CHANGE OF USE OF EX-BELL PUBLIC HOUSE TO A SHOP (CLASS E) INCLUDING PART DEMOLITION, SINGLE STOREY REAR EXTENSION & EXTERNAL WORKS

**THE BELL INN, 33 CHURCH STREET, PINCHBECK, SPALDING, LINCOLNSHIRE, PE11
3UB**

Application No H14-0523-26

Comments on consultation responses

PROPOSED SITE LAYOUT
scale 1:200

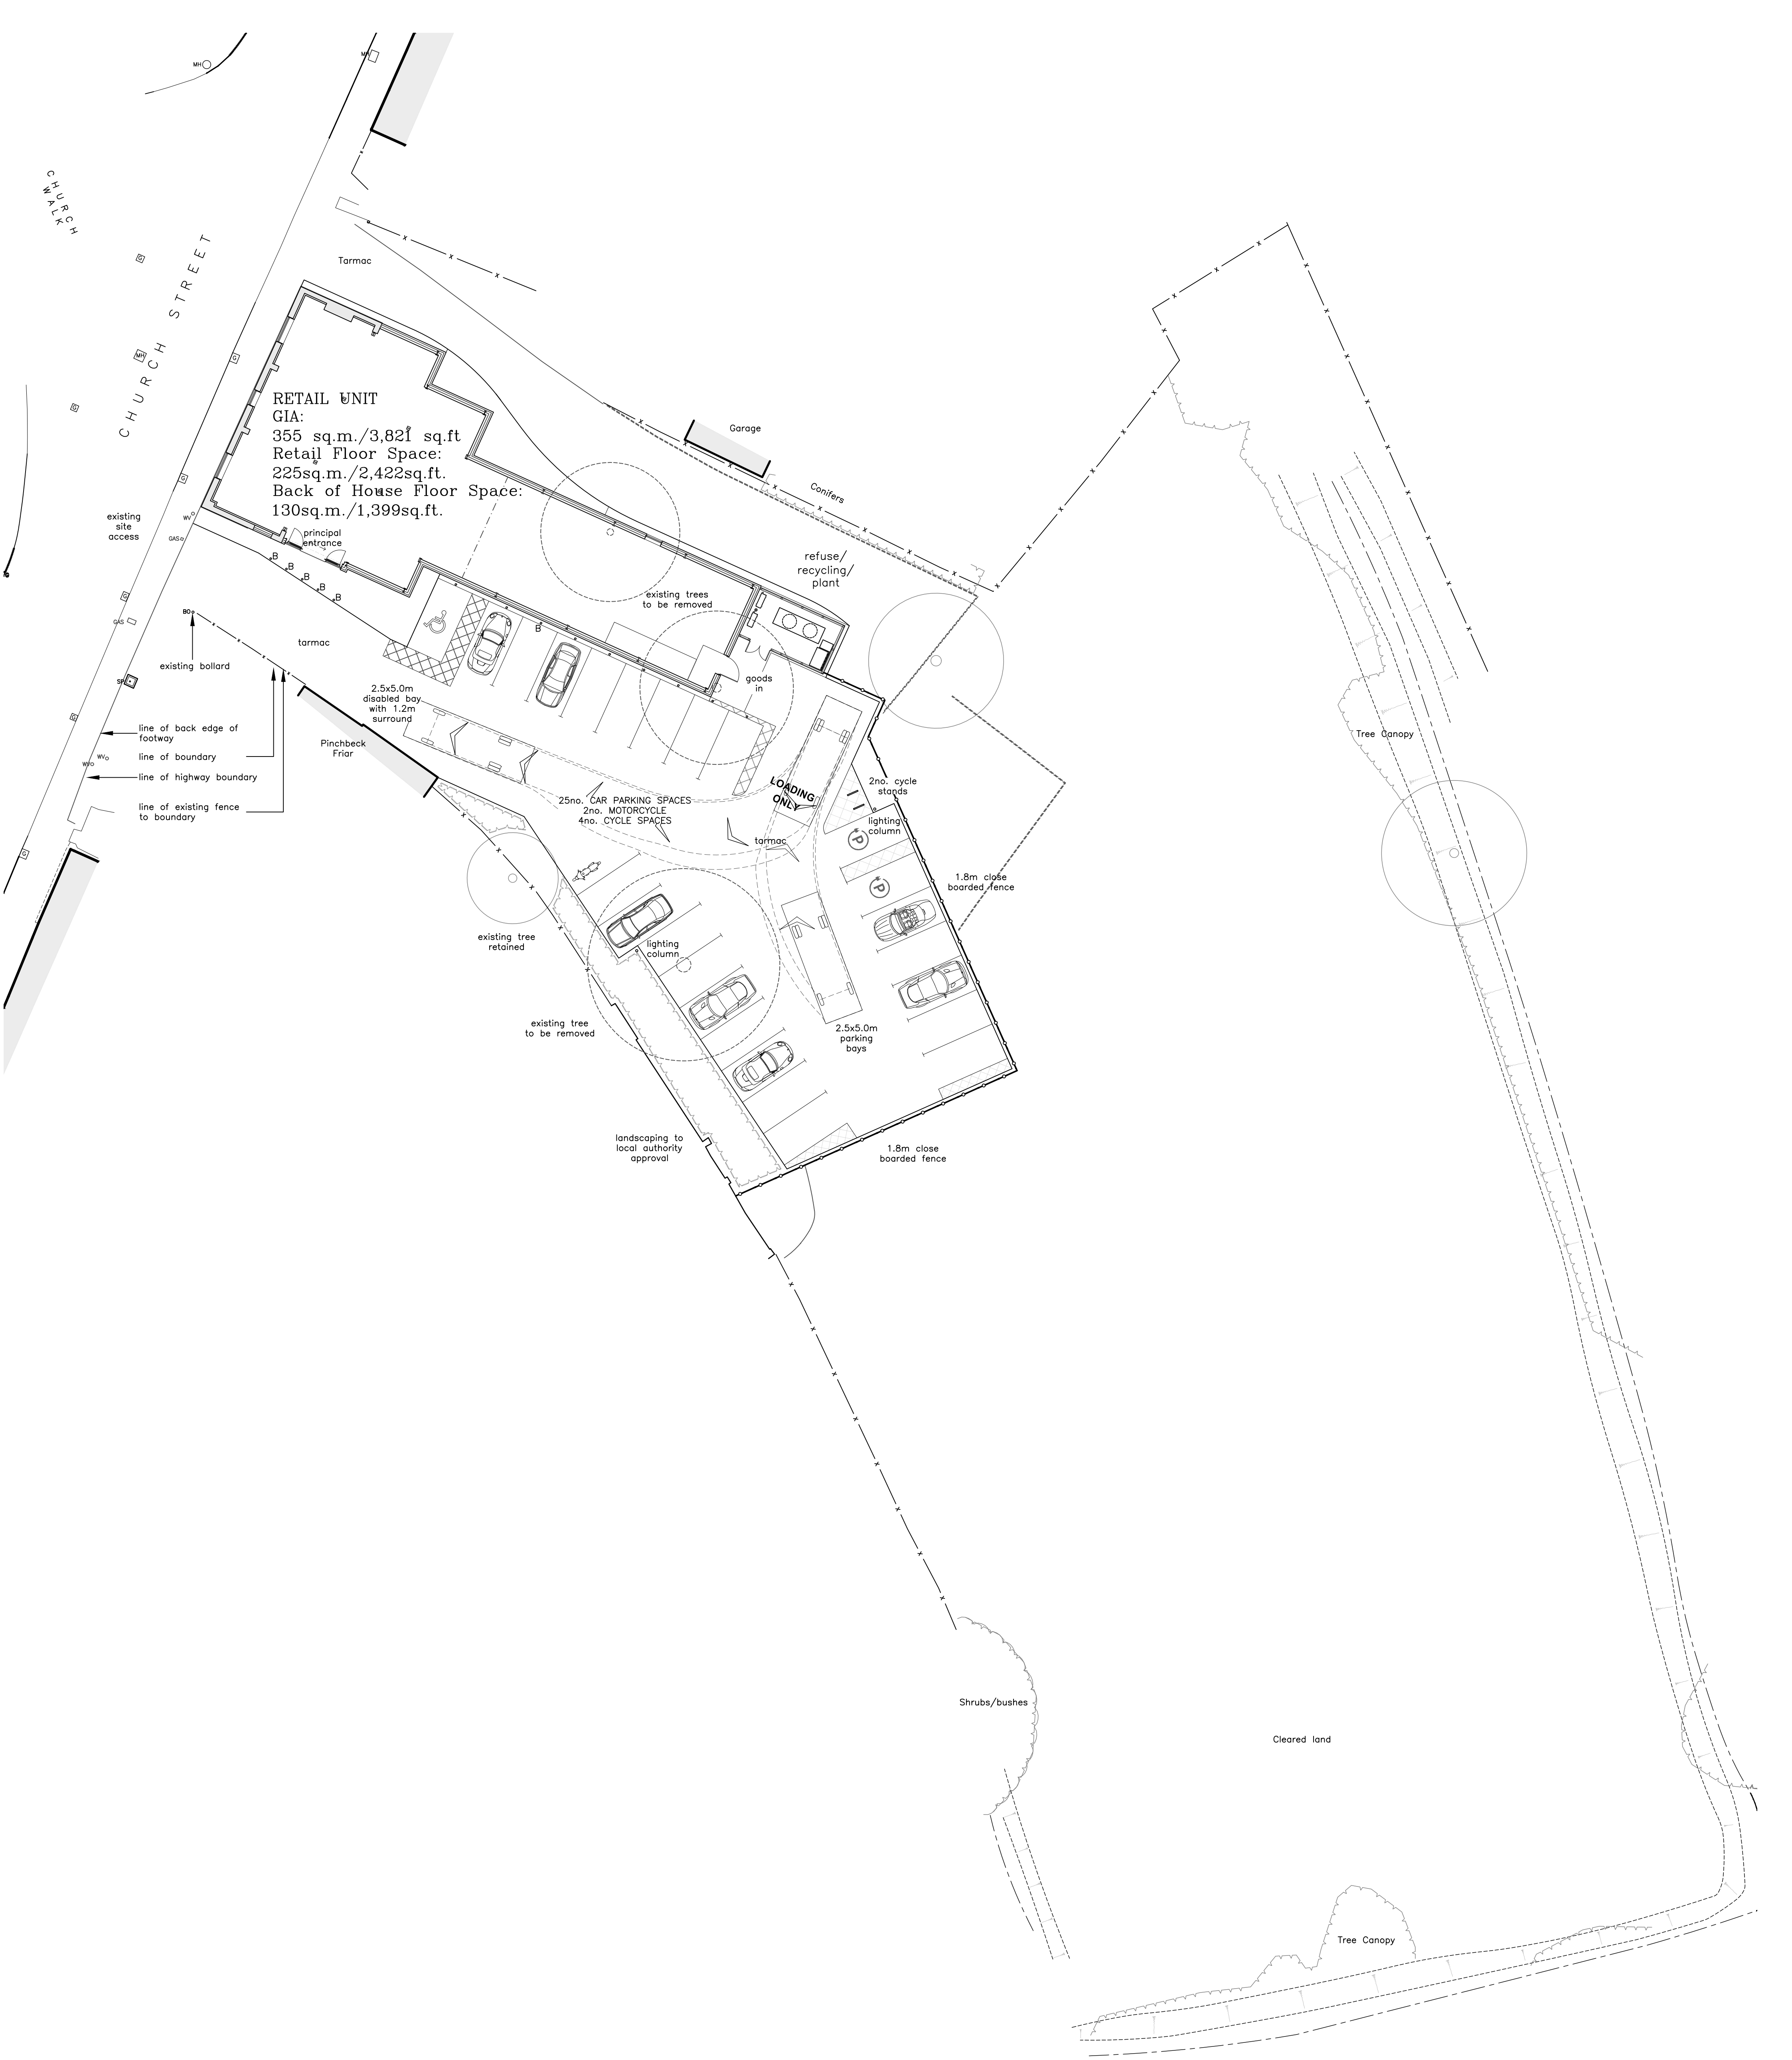
1 ☐ The preliminary roost assessment identified that tree T443 contains two potential roost features; however, no evidence of roosting bats was recorded at the time of survey. The proposed development includes the removal of this tree. Given the recorded bat activity within the area, we recommend that T443 is retained and incorporated as a feature within the car park. This would ensure the retention of two potential bat roosting features on site. BNG Comments and Notes to applicant ☐ Overall, the biodiversity assessment and metric calculations appear rigorous, and we can have confidence in their conclusions. In this case the metric indicates that 10% mandatory net gain cannot be achieved on-site, and therefore the proposals require 1.14 area-habitat units on-site. These will need to be secured pre-commencement and can be achieved via 2 routes:

☐ If the tree T443 was to be retained as previously mentioned, the only 0.95 units would been to be secured pre-commencement. ☐ The metric indicates that 10% mandatory net gain can be achieved on-site with a predicted overall gain of 221.67% in Habitat units Specific BNG condition request ☐ We will require a biodiversity gain plan and all the appropriate onsite details and a finalized metric to be provided for this application.

Retention of T443 has been carefully considered. However, its retention would result in the loss of four parking spaces and the principal turning area, thereby potentially creating the highway and parking concerns identified by the Parish Council and previously raised by the Highway Authority. The layout cannot therefore reasonably accommodate the tree without prejudicing the safe and effective operation of the site. Appropriate ecological compensation will be incorporated into the biodiversity gain arrangements. This should also be weighed against the substantial benefit of securing the viable reuse and long-term retention of the former public house, which is identified as a non-designated heritage asset.
